Re: M/56/15/HH - 31 Sea Way, Middleton on Sea, PO22 7RZ

Having discussed with our client, we wish to amend our proposal and submit the following substitute plans:

- 14029-03-A (Plans)
- 14039-04-A (Elevations and sections)
- 14039-06-A (Block plan)

14039/03

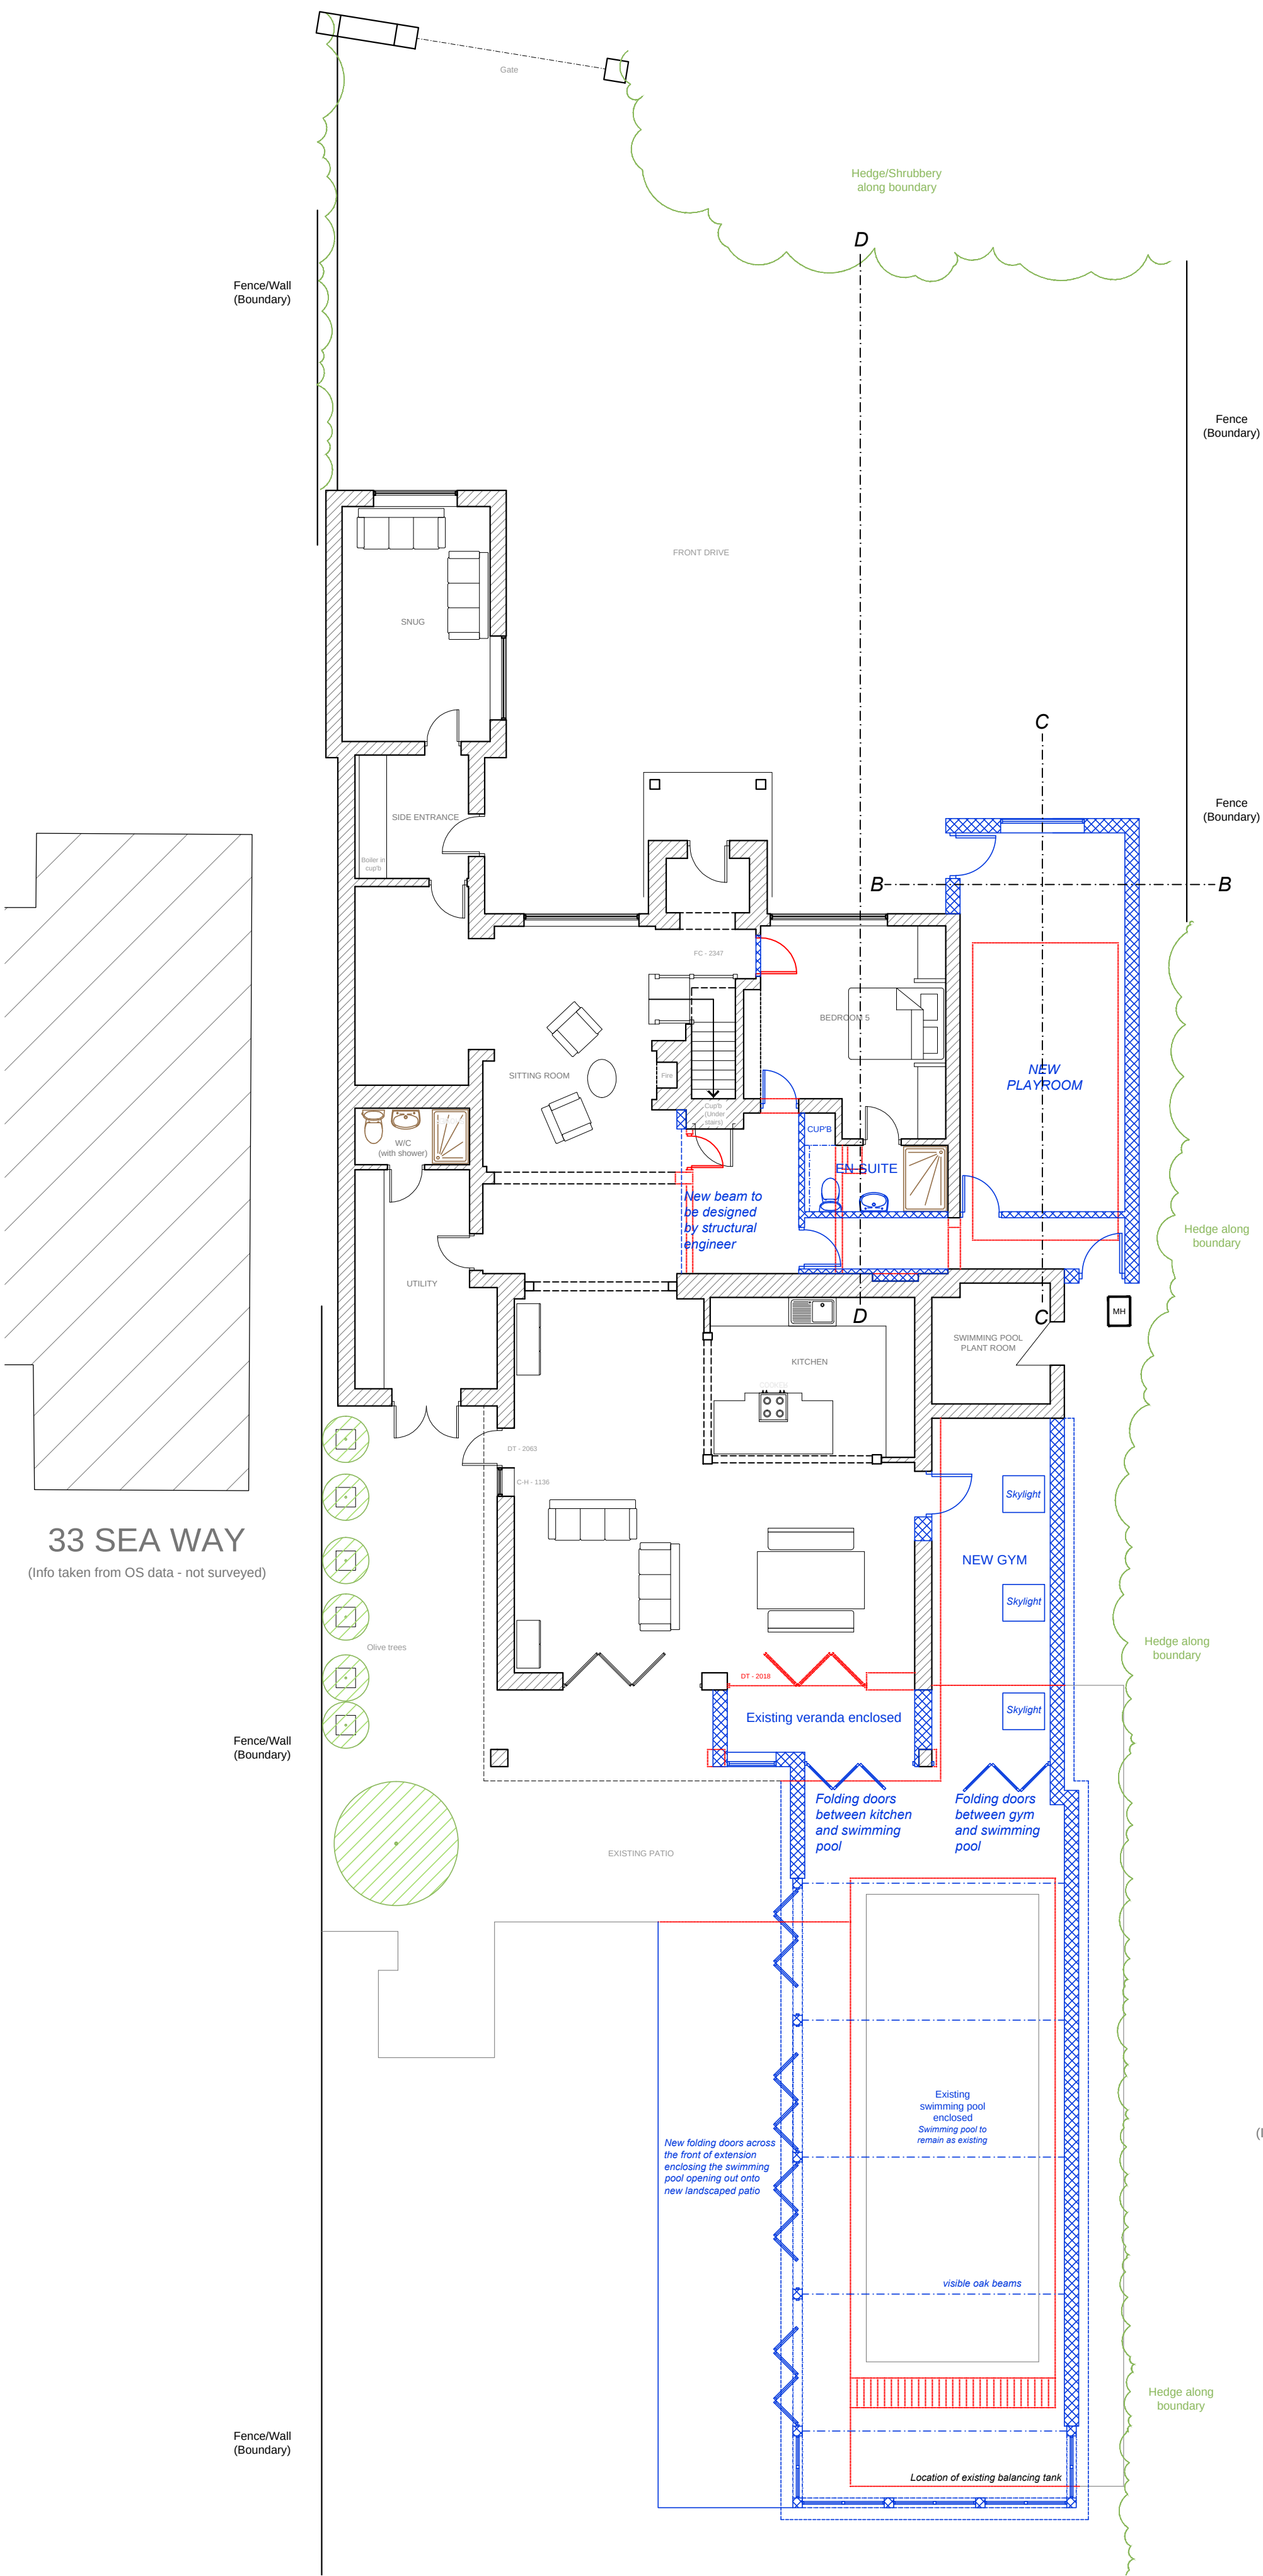
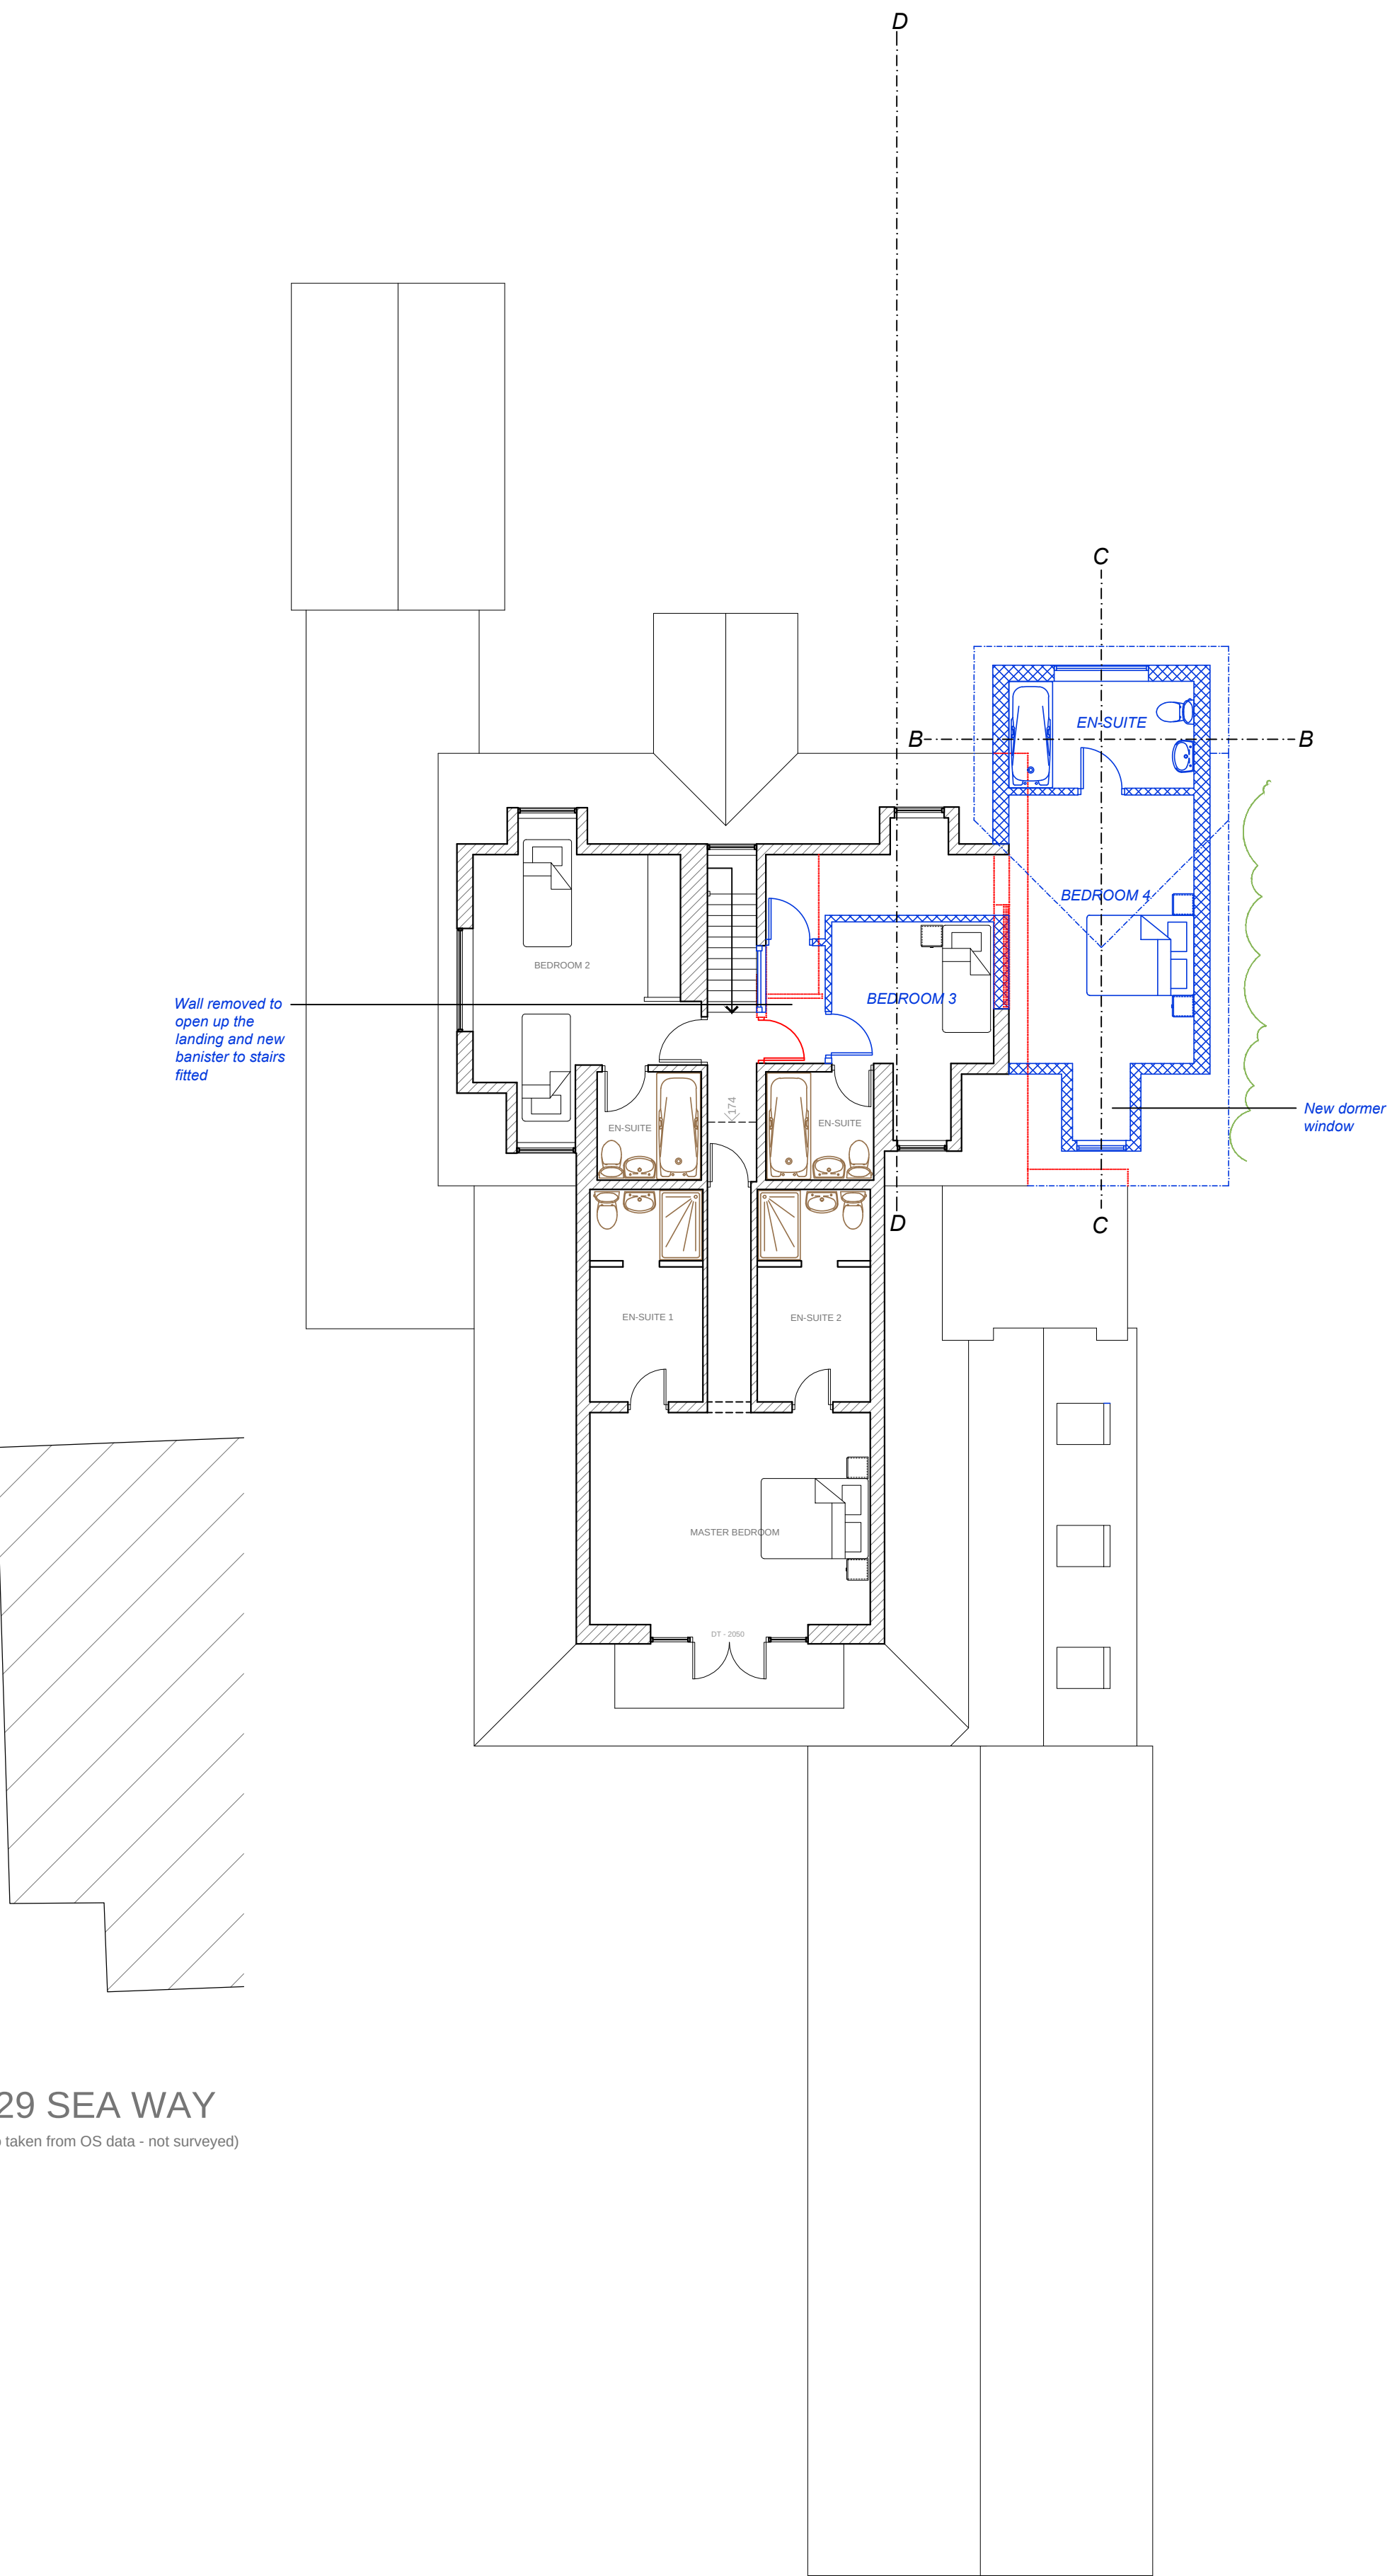
1. Omitting the proposed carport to the front of the property.
2. Reducing the pitch of proposed extension to enclose the existing swimming pool from 31.6° to 25°. This reduces the height of the ridge by 480mm.
This roof is proposed to slope away from the boundary so it does not overpower the boundary with No29 Sea Way. The shrubbery along the boundary between 31 and 29 Sea Way is to be retained which will help screen the proposed extension.
